# 2103190 SEASCAPE HOMES Lot 3 Upper Floor 18" Depth 16" OC

## SHOP DRAWING / SUBMITTAL REVIEW

L120 ENGINEERING & DESIGN

2103190
SEASCAPE HOMES Lot 3
Upper Floor
18" Depth
16" OC

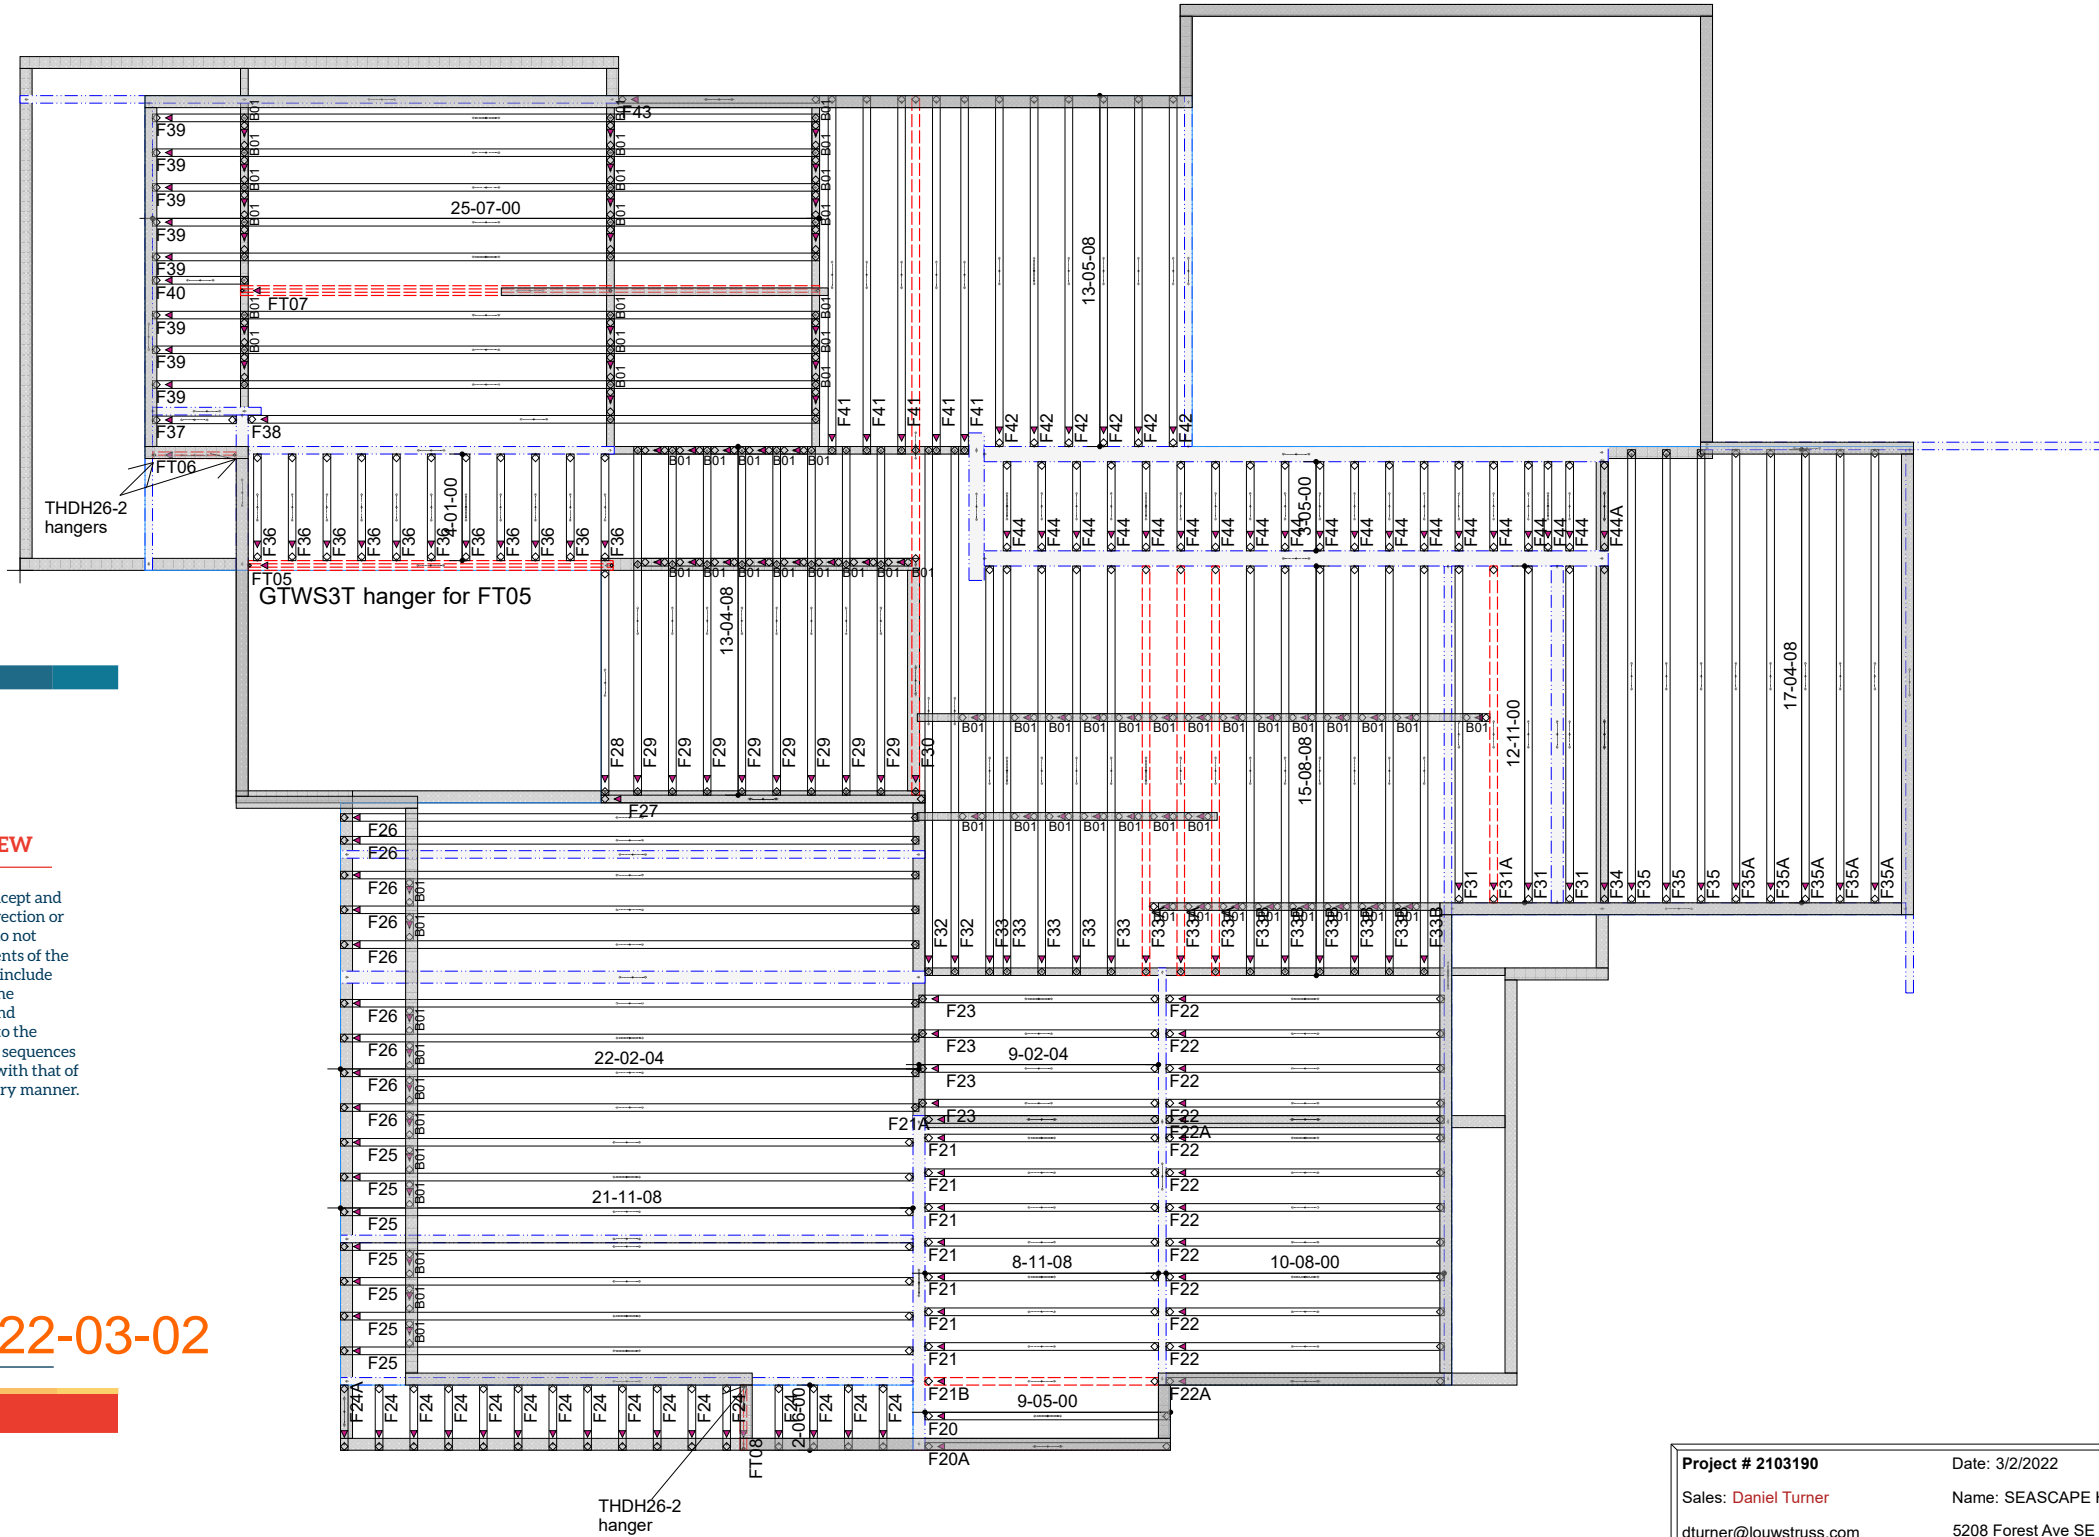
ADD FLOOR TRUSSES, REF SHEET S-6
